MMC Encroachment License

Hi Nell. I've taken a quick look at what was recently sent to you. The attached exhibits do not meet the standard of what we are looking for to convey a license or an easement. We need either (1) an exhibit plan produced by a licensed land surveyor that clearly shows the boundaries of the license area labeled with precise bearings and distances and abutter calls as well as accurate ties to the nearest street line corner, or (2) a written description produced by a licensed land surveyor that includes the same information as I've described for the exhibit plan. Preferably, we would receive both of these but either one will do.

Drawing file: originals / Pedstrian Easement Exhibit A 2020 0515.pdf

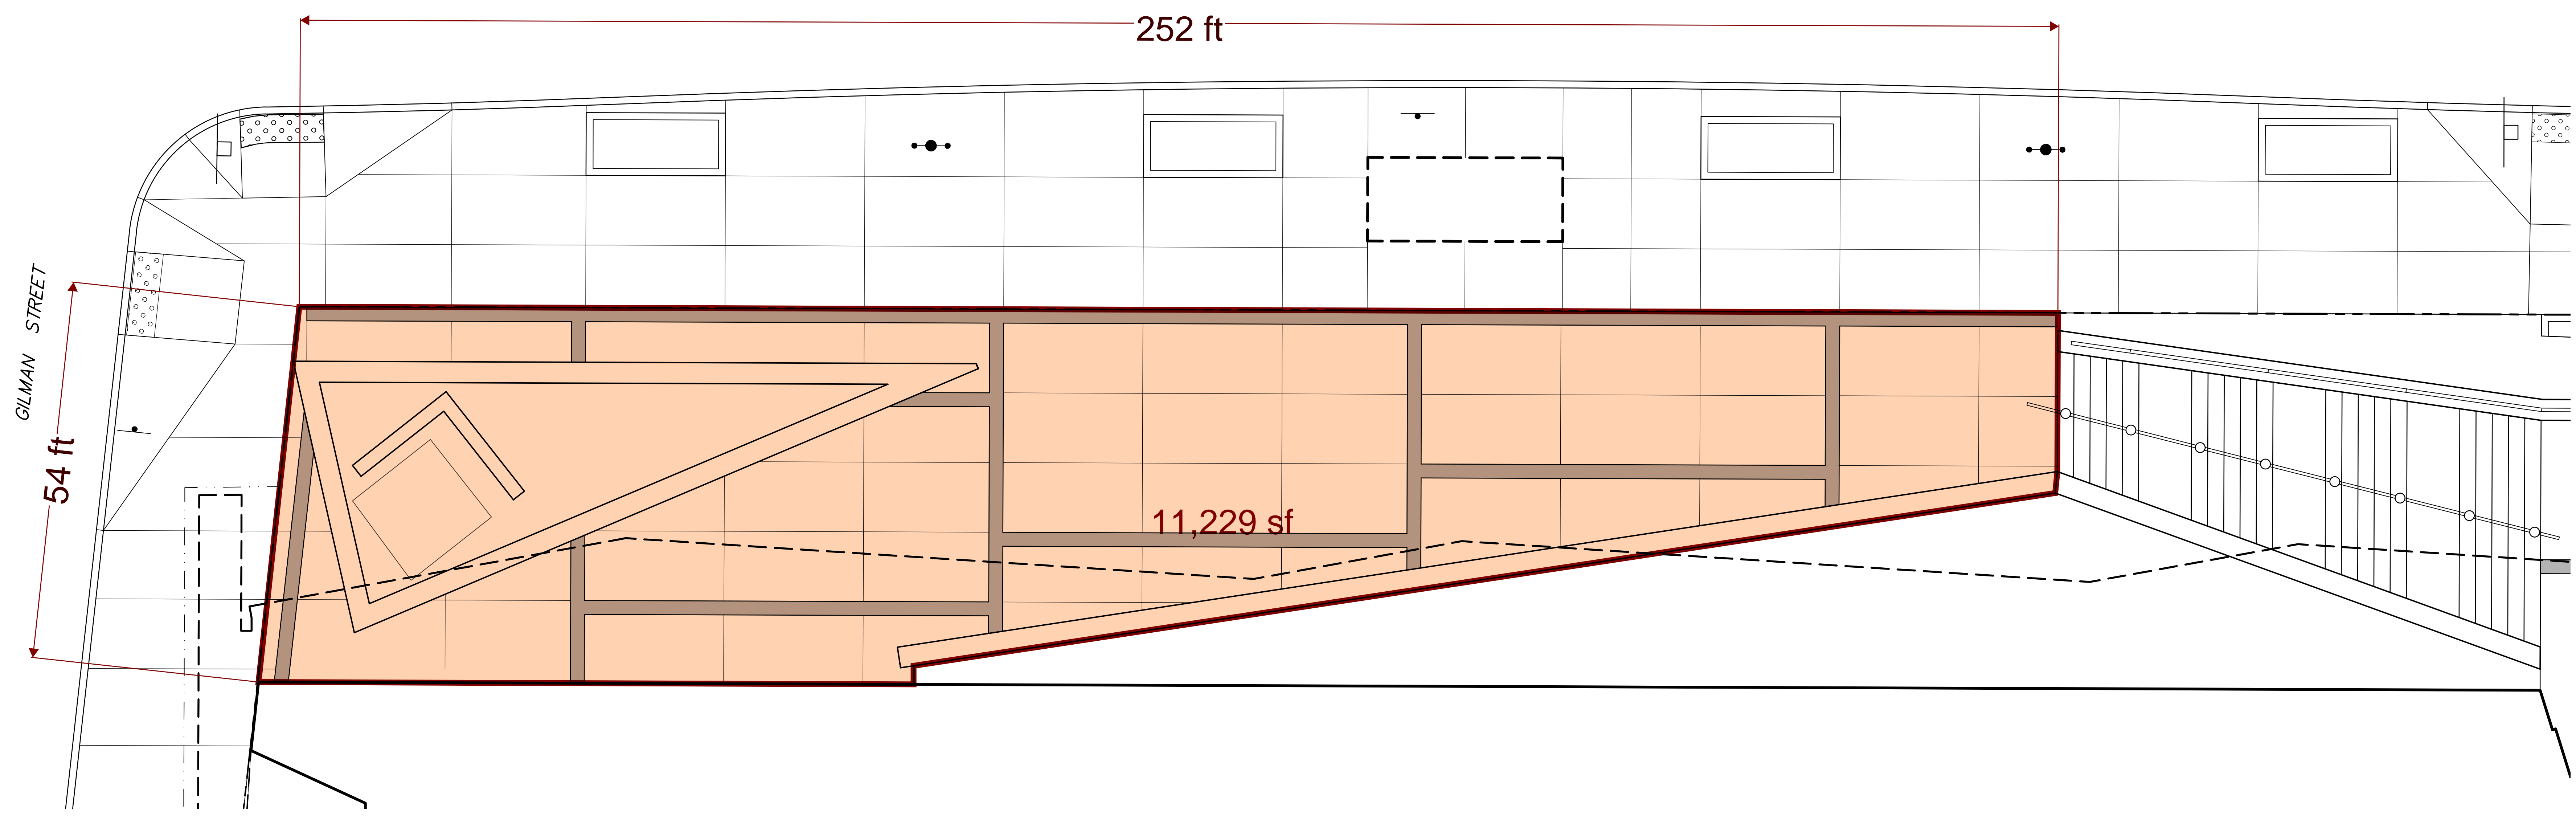
We need something more precise than what has currently been delivered to us. And I think a surveyor should be producing the exhibit and/or deed description, not an architect or engineer.
